Application for a non-material amendment following a grant of planning permission.

2 The Strand and beach hut
East Preston

FG/128/15/NMA

Application for a non-material amendment following the grant of planning permission FG/95/15/PL for revised dimension of beach hut.

REVERSE DRWG 3A
SHOWING INCREASE
IN LENGTH ONLY

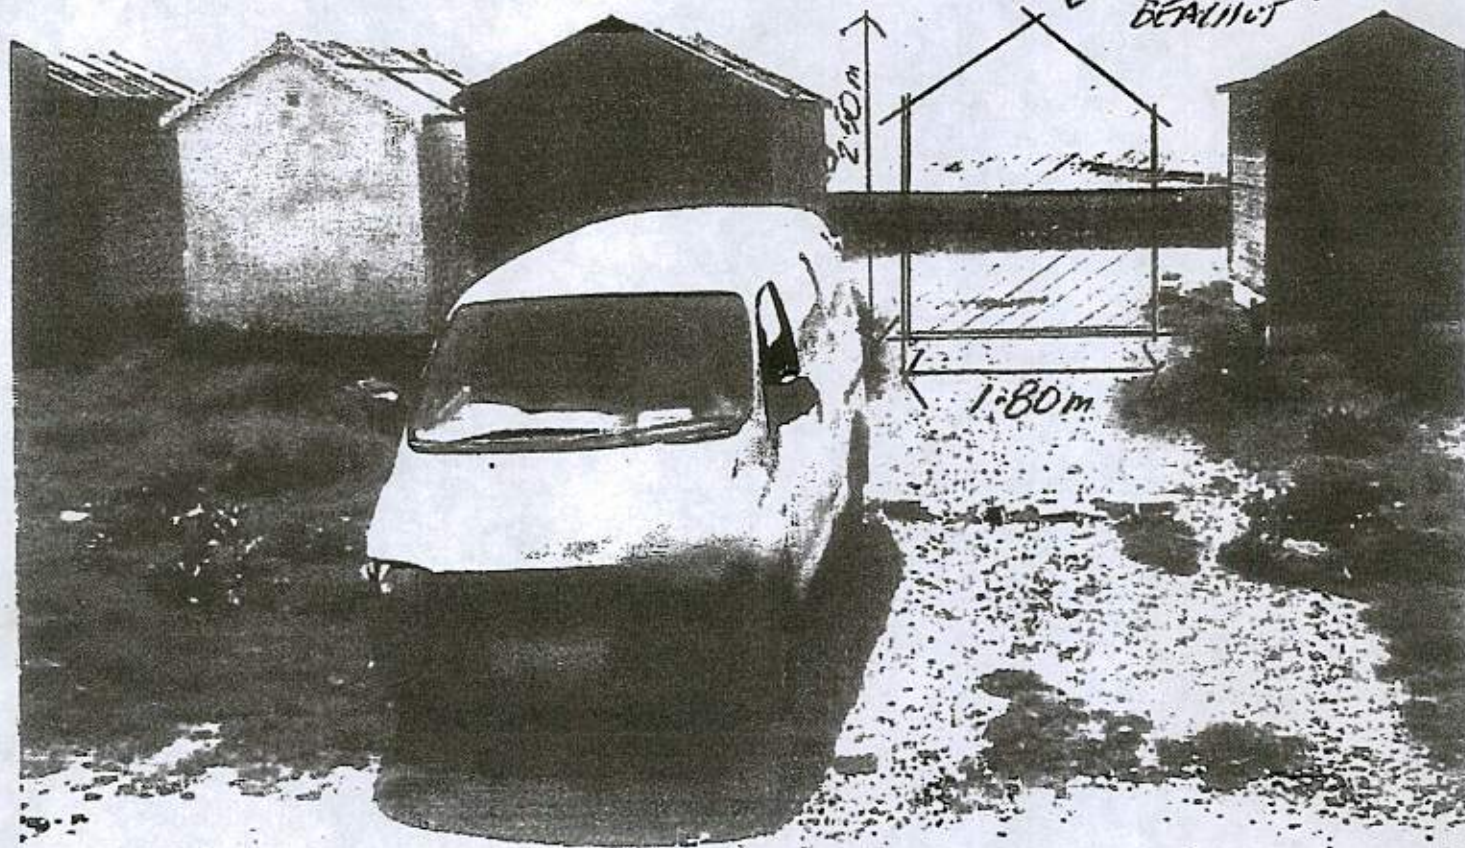
THE ORIGINAL APPLICATION STATED THAT THE DIMENSION OF THE BEACH HUT WOULD BE 2.4M LONG X 1.8M WIDE. THIS WAS SUBMITTED IN ERROR. THE LENGTH THAT SHOULD HAVE BEEN SUBMITTED IS 3.0M (THREE METRES) LONG. - THE WIDTH REMAINS THE SAME. THE REVISED LENGTH ^{WILL} ~~SHOULD HAVE~~ COMPLEMENTED MY EXISTING BEACH HUT.

I ~~WISH~~ WISH TO APPLY FOR AN AMENDMENT BASED ON AN INCREASE OF BEACH HUT LENGTH OF 600mm.

N° 3A & N° 5A
